RE: Response to Submission, Australian Technology Park, South Eveleigh (SSD 7317, MOD 17)

Table 1 Response to comments from Council

Table 2 Response to comments from the Department

**Figure 3** Proposed Upper Ground Floor Retail Layout for Building 2

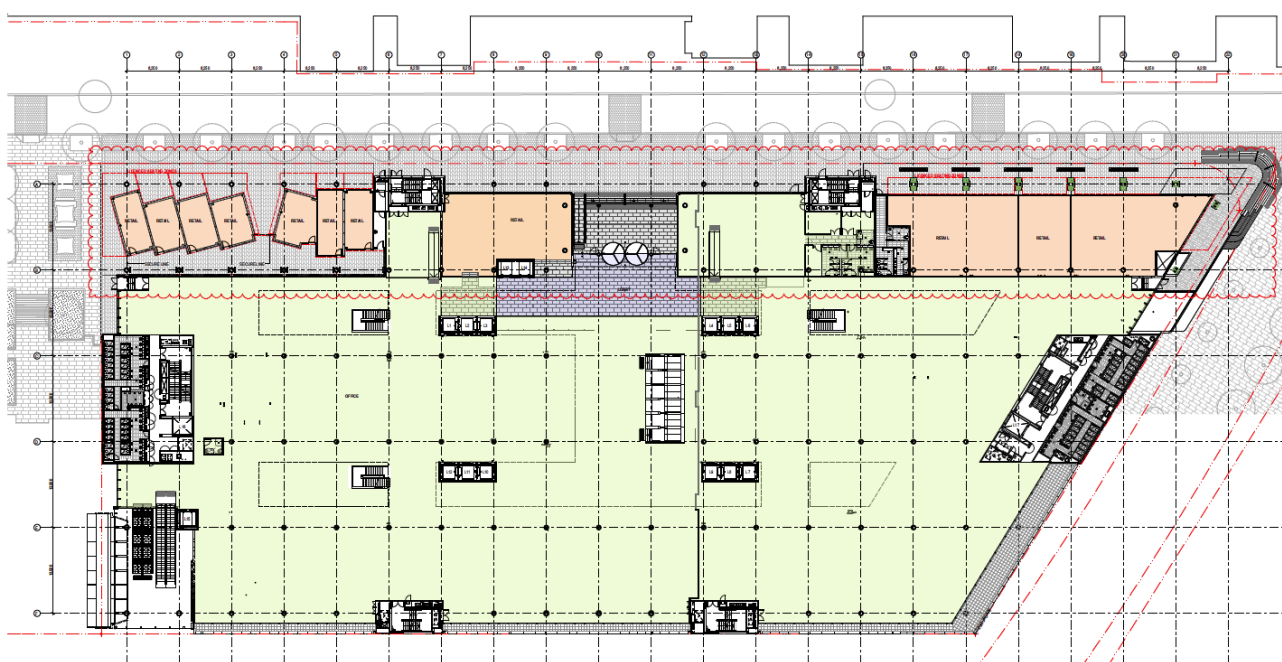
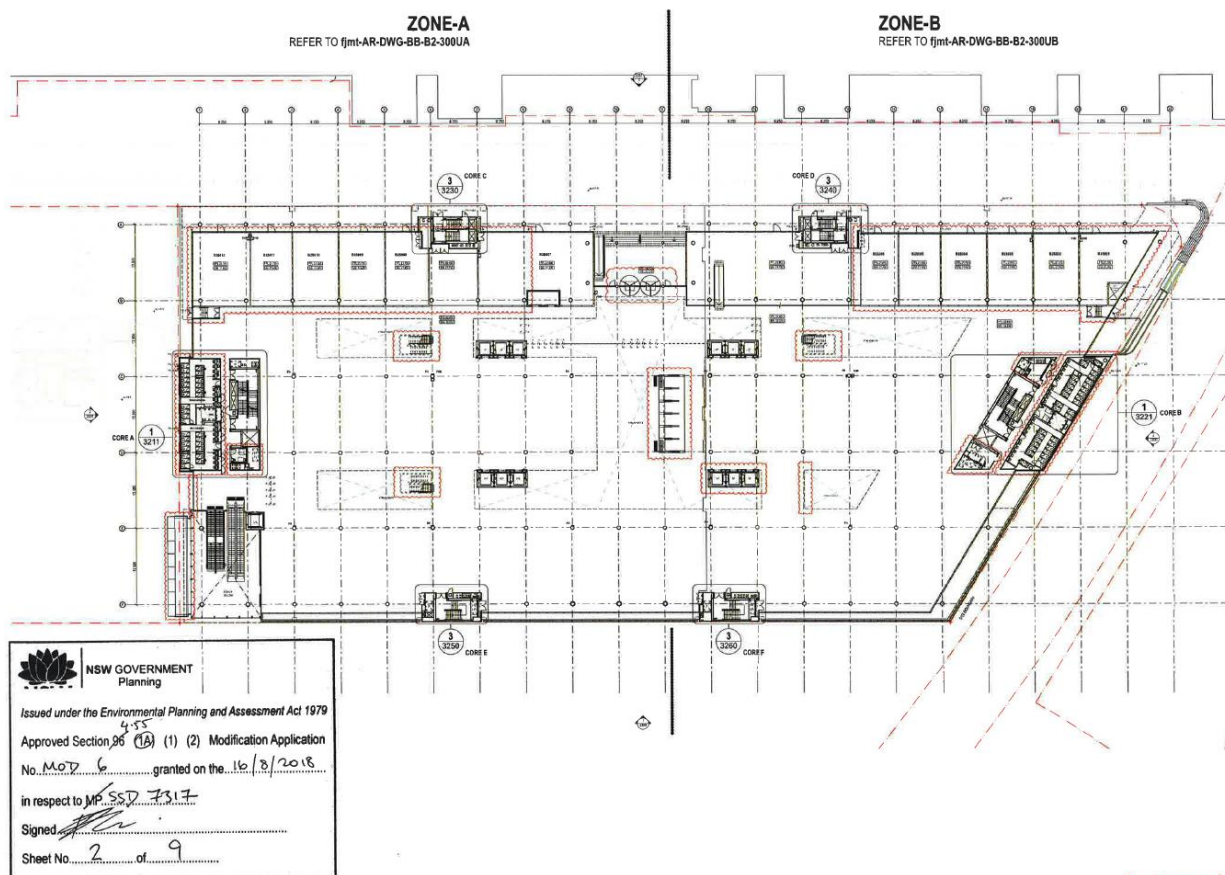
Issue	Comment / Response
Reconfigured Tenancies	
The reconfiguration of the tenancies was presented to the City of Sydney on 30 July 2019 during a pre-lodgement meeting with Mirvac. The City does not object to the proposed size, amalgamation of the tenancies, or 'container' approach for the retail tenancies, except where noted below.	Mircac's vision for the area located behind the container style tenancies is for a quieter seated dining area, shielded from the substantial foot traffic along Locomotive Street.
As noted during this meeting, the layout of the retail tenancies should be redesigned to allow for an additional opening next to the amenities of the north-east of the site for the rear external seating area (in blue outline below). This may result in the loss of some retail GFA but would provide for additional amenity for patrons.	The creation of additional opening for the rear seating area would undermine this vision and create conflict with the building services required to service the Western Retail Units. There is a void above each of the containers. This void will provide airflow to the rear area, without the need to create an additional opening. It is also noted that shifting the containers to the west to accommodate the additional opening would result in the western container being too close to the edge of the building, where it would be affected by inclement weather.

On this basis, Mirvac propose to retain the existing configuration proposed for the Western Retail Units.

**Figure 5** Location of Proposed Signage Zones along Locomotive Street

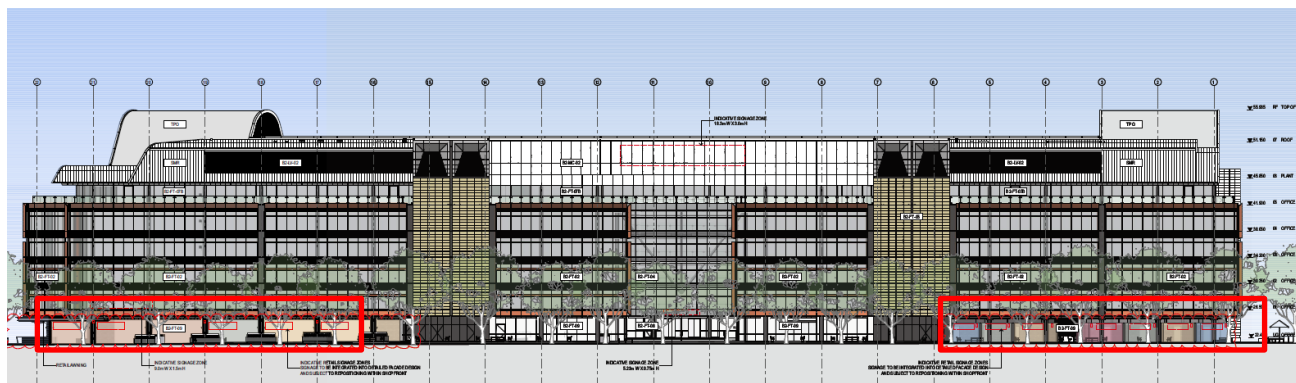
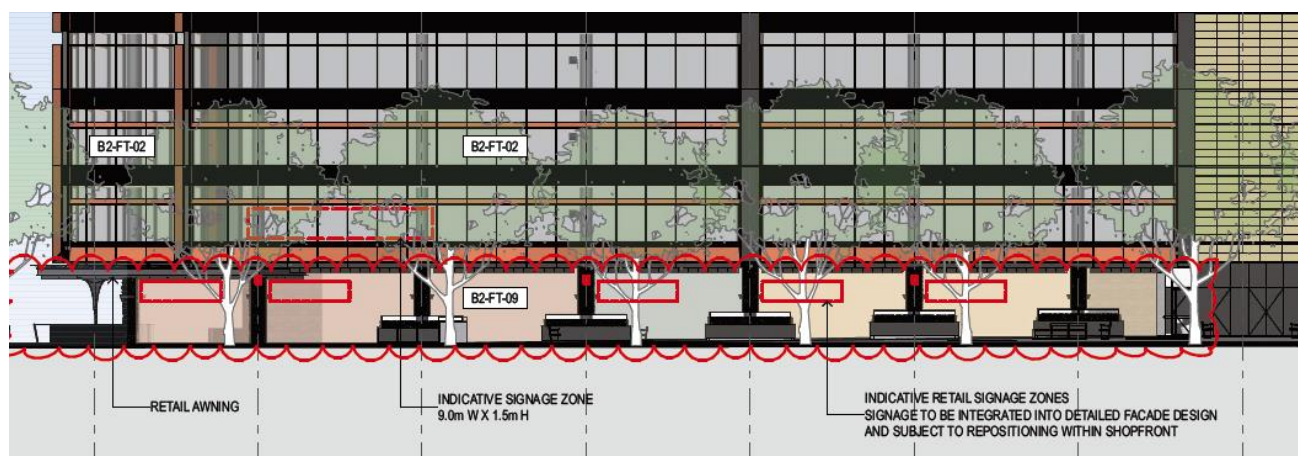
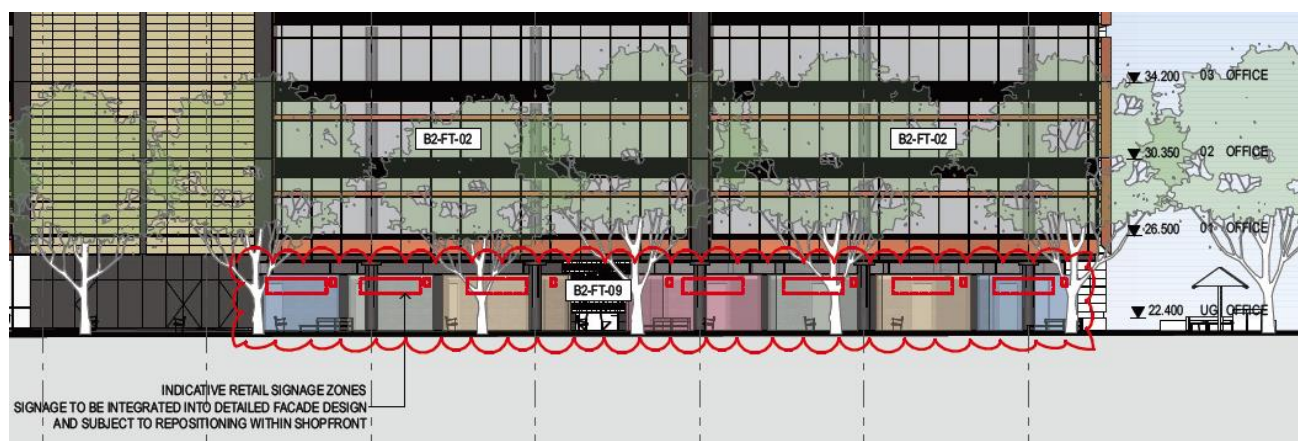
Issue	Comment / Response
Signage Zones along Northern Elevation	
<p>The information provided for the 'Indicative Signage Zones' and 'Indicative Retail Signage Zones' is insufficient for the purposes of an assessment. The size and proposed locations of these zones, materiality and limits to the number of signs per tenancy should be confirmed via the submission of a comprehensive Signage Strategy to be endorsed in consultation with the City of Sydney. The City objects to the signage zones unless the above is addressed.</p>	<p>Following additional post-lodgement consultation with Council, Mirvac have agreed to submit details of the final signage design, content and illumination (if proposed) within the 'Indicative Retail Signage Zones' to Council for approval prior to the installation and display of any signage.</p> <p>A new condition F7A has been proposed to read as follows:</p> <p><i>F7A Retail Signage Zones along Locomotive Street</i> <i>Details of the final signage design, content and illumination (if proposed) generally within the approved indicative retail signage zones along the Upper Ground Floor of Building 2 are to be submitted to Council for approval prior to the installation and display of any signage.</i></p> <p><i>Council may approve retail signage outside the indicative retail signage zones where they are satisfied that the proposed signage is appropriate and compatible with visual appearance of the Upper Ground Floor of Building 2.</i></p>
